Re: Zero Canal Plaza Development
Level II Site Plan Application – Response to Comments

Review Memos from Caitlin Cameron, dated 8/3/16

Engineering Review memo from Stephen Bushey, dated August 1, 2016

**TREE DRAIN AND SAND BASED STRUCTURAL SOIL DETAIL**  
N.T.S.

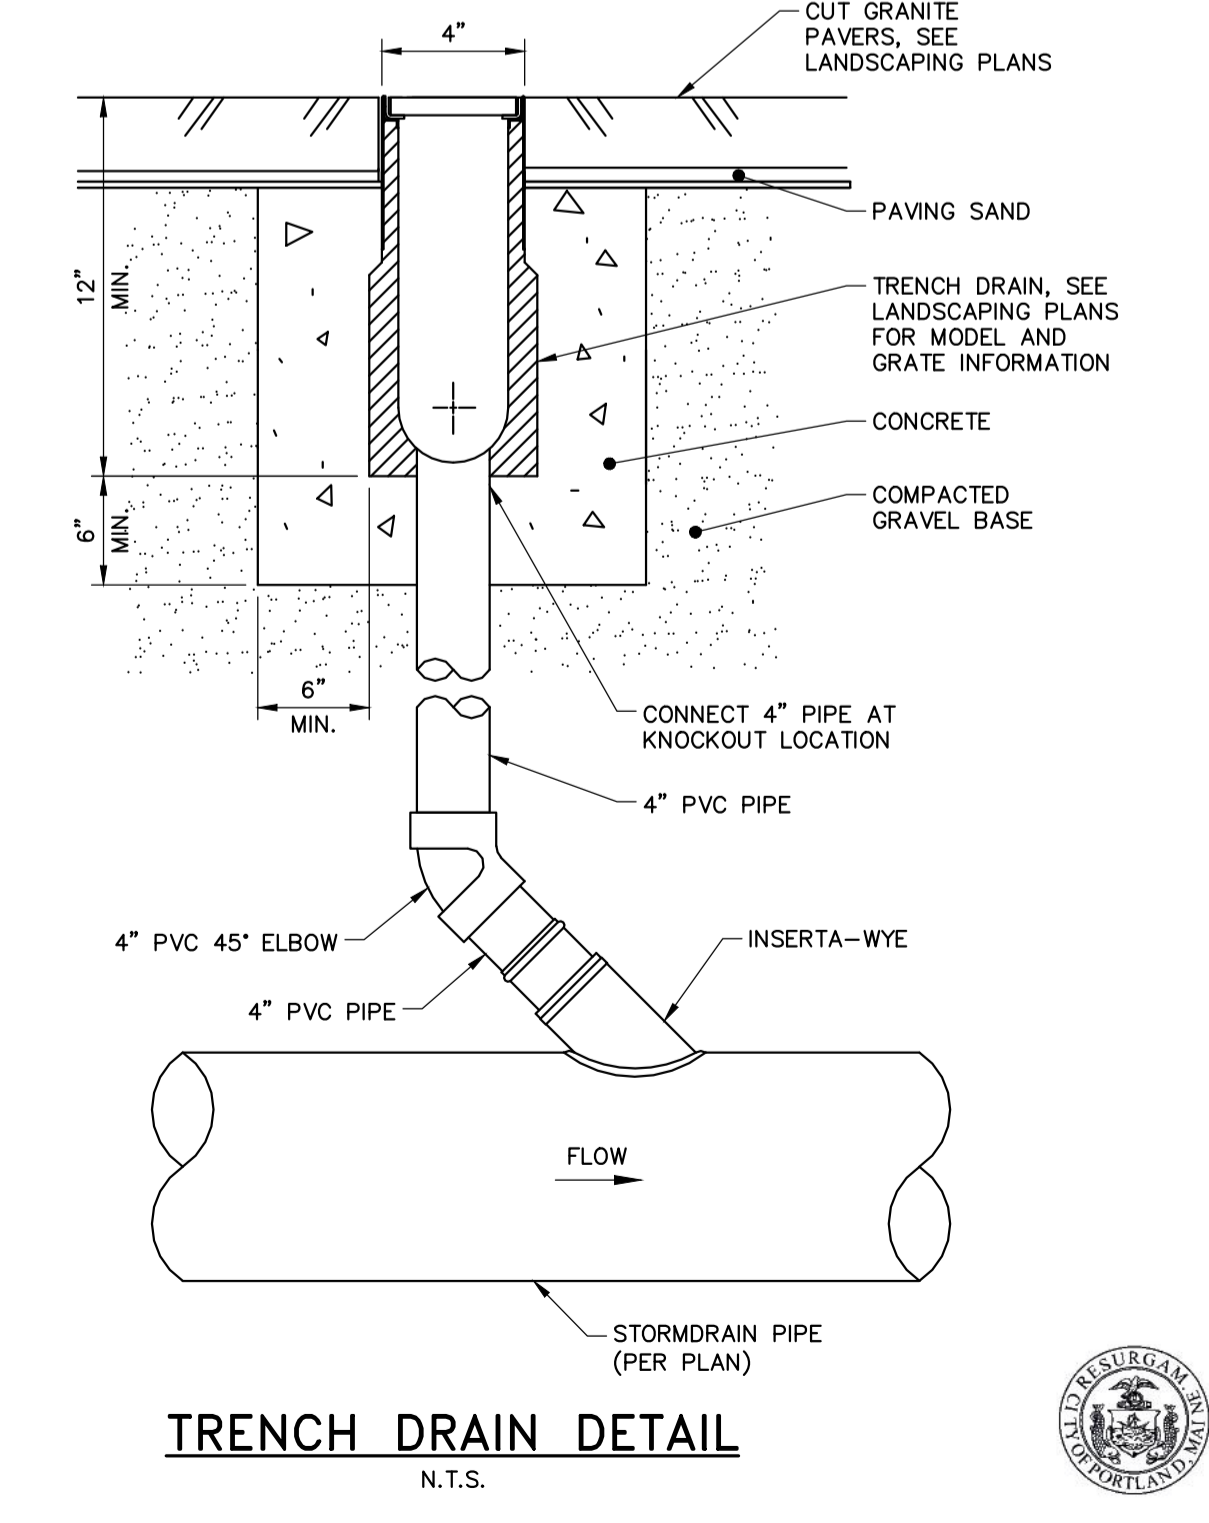
3. *Will structural soil be used within the planting zones to help with the tree growth?*

Structural soils will be utilized within the tree planting zones. The structural soils are being designed for inclusion in the final Construction Documents for the project.
